10 January 2024

**RE: OBJECTIONS to planning application reference 23/01451/FUL seeking to amend approved planning application 21/00701/FUL dated 14.02.22 by adding an additional fourth floor to the partly constructed new building at Friars Garth, The Parade, Epsom, Surrey KT18 5DH**

Third Floor Plan
1.100 @ A1

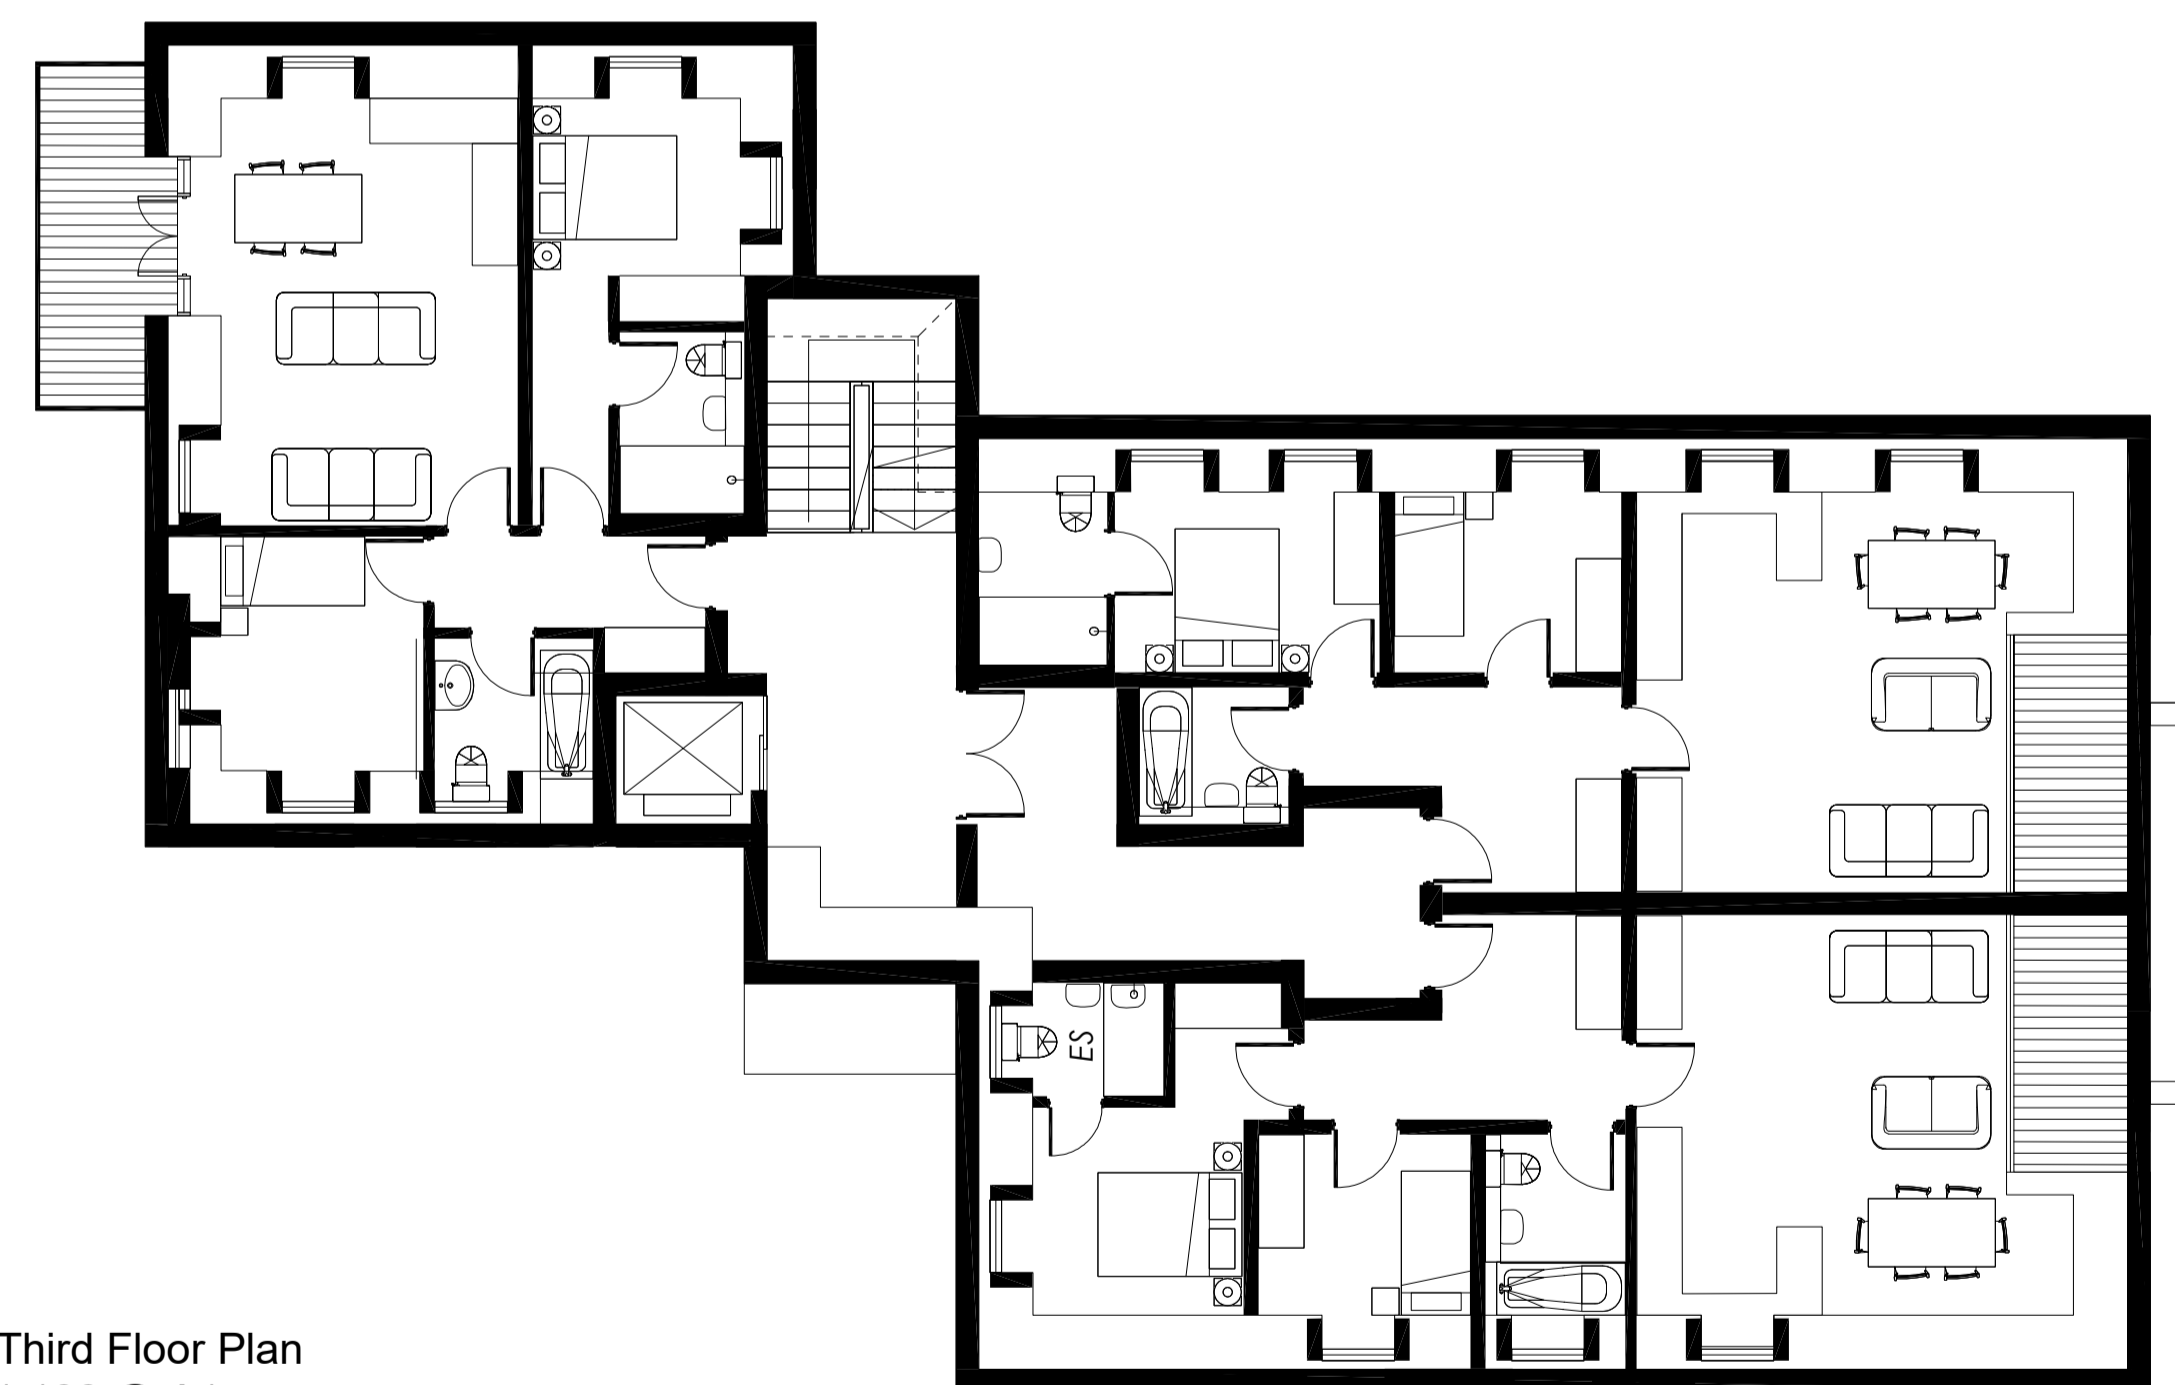
**Density of occupation.** As mentioned above, the high density of the approved block of nine flats was already flagged up as an issue of concern at the Planning Committee meeting on 13 January 2022. Latchmere Properties, the applicant at the time, acknowledged this high density occupation in the planning statement (see paras 6.4, 7.17, 7.19, 7.20, 8.30 & 8.52) but considered it justified. To add a fourth storey and three additional flats would make an already unsatisfactory situation worse.

**Lack of amenity space.** As mentioned above, the insufficient lack of amenity space for the approved block of nine flats was already flagged up as an issue of concern at the Planning Committee meeting on 13 January 2022. To add a fourth storey and three additional flats would make an already unsatisfactory situation worse.

**Overshadowing, overlooking and loss of privacy.** The planning officer's report (paras 9.40, 9.41) prepared for the Planning Committee meeting of 13 January 2022 acknowledged that there would be "some overshadowing to No.7 The Cressinghams" and that the proposed balconies would be at an oblique angle to Nos. 7-9 The Cressinghams. To add a fourth storey and three additional flats - with a further balcony four floors high at the rear- would make an already unsatisfactory situation worse.

**Blocking of light.** Adding a fourth storey will result in increased blocking of light to houses on The Cressinghams estate and beyond; it will also result in additional electric light pollution at night.

**Technical considerations.** There may be questions concerning the planned additional loading on the foundations, the increased drainage, and whether there would be sufficient staircase provision for a fourth floor.
